KIRKLEES METROPOLITAN COUNCIL INVESTMENT & REGENERATION SERVICE

DELEGATED DECISION TO DETERMINE PLANNING APPLICATIONS

Reference No:	2023/62/93140/W
Site Address:	Hillside, 6, Almondbury Common, Almondbury, Huddersfield, HD4 6SN
Description:	Erection of dormers to front elevation and extension of existing garage
Recommending Officer:	Joanna Rednall

DECISION – Conditional Full Permission

Rev	Description	Date	By	App'd
Project 6 Almondbury Common, Almondbury HD4 6SN		Project Ref. 23-011	Date 26/10/23	
Drawing Title Site Plan as Proposed		Scale @ A3 1 : 200	Drawn by DH	Appr. by MO
Client V Davenport		Drawing No. AL0002	Rev

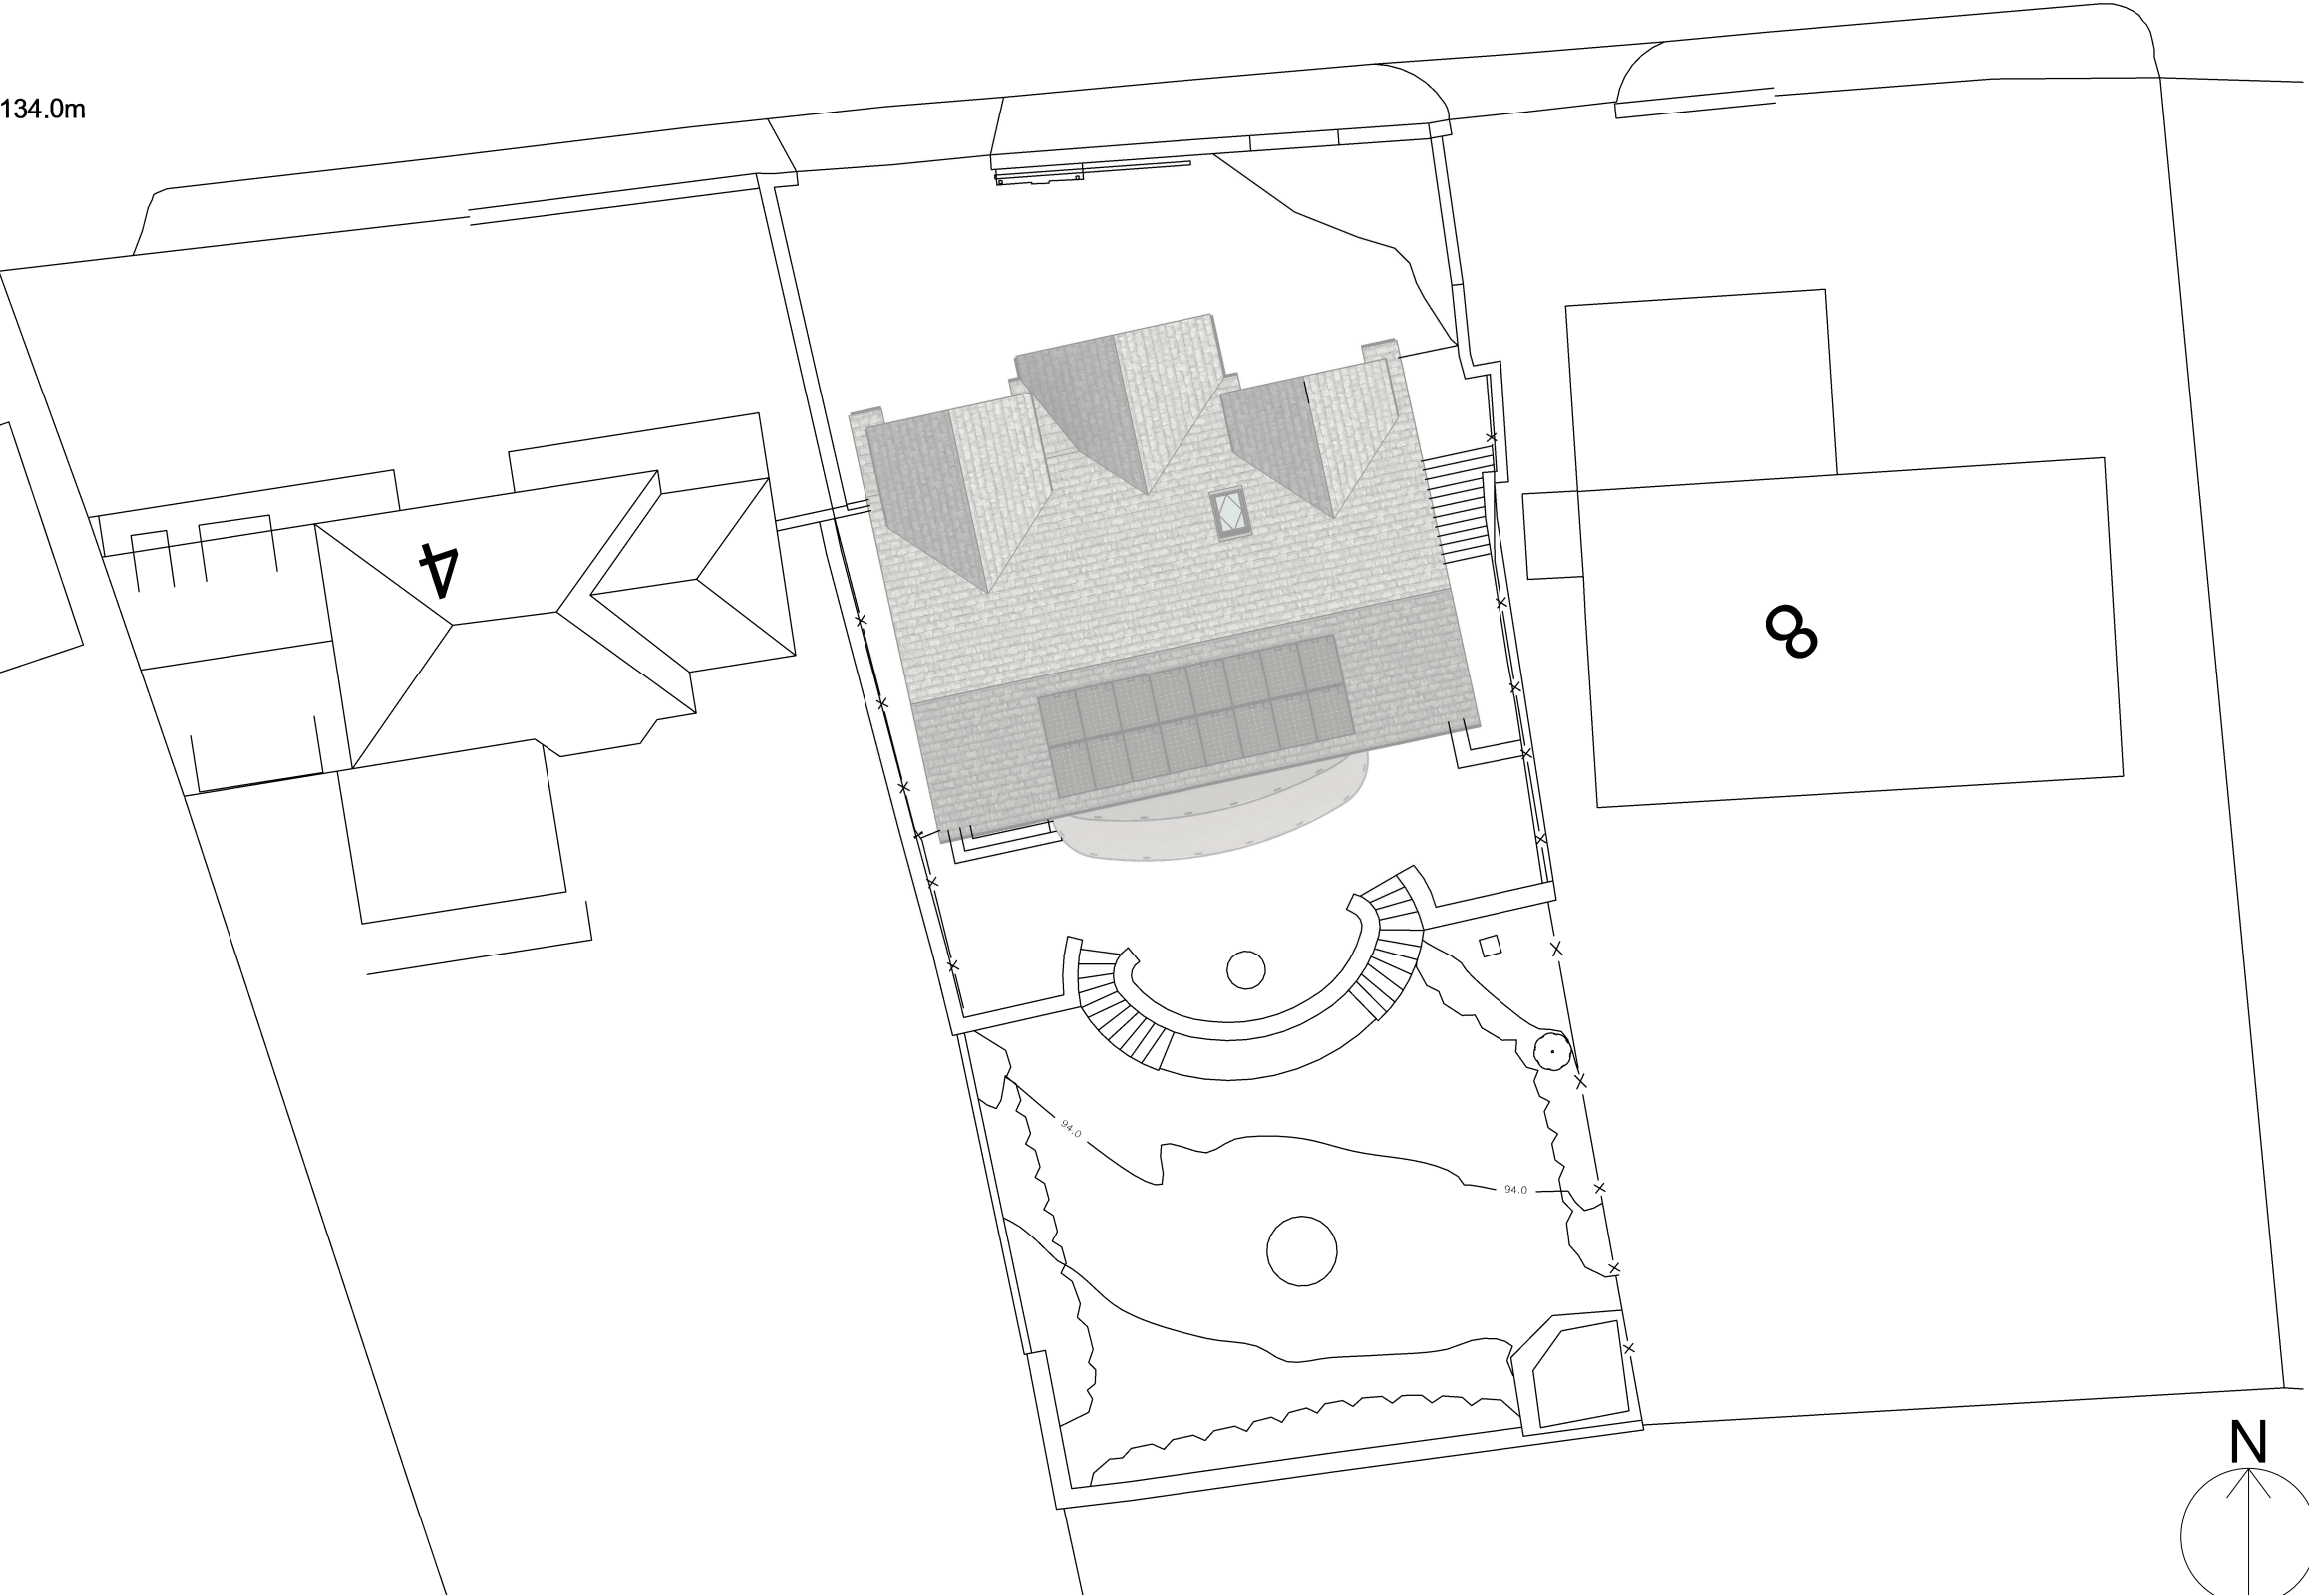
The proposed garage extension would be almost identical to the existing with the walls constructed using stone with a cream door but extend ~0.2 metres in width which is acceptable in this case. In terms of the garage extension, despite the ~1.2 metre front extension, the proposed plans show it would be

~1 metre behind the principal entrance and front elevation of the dwelling. Despite this, the extension would be ~6 metres back from the pavement therefore it is unlikely that it would have detrimental impact on the character of the street scene. Screening of the boundary wall is also in place.

With regard to parking arrangements, the number of off-street car parking spaces required would be increased to 3 as a result of the proposed works increasing the number of bedrooms from 3 to 4 bedrooms. The proposed garage would be ~3.6 metres by ~6 metres internally and would be sufficient to accommodate parking space for one vehicle. The front of the property would accommodate off-street parking and room for turning for two vehicles and is considered acceptable in this case.
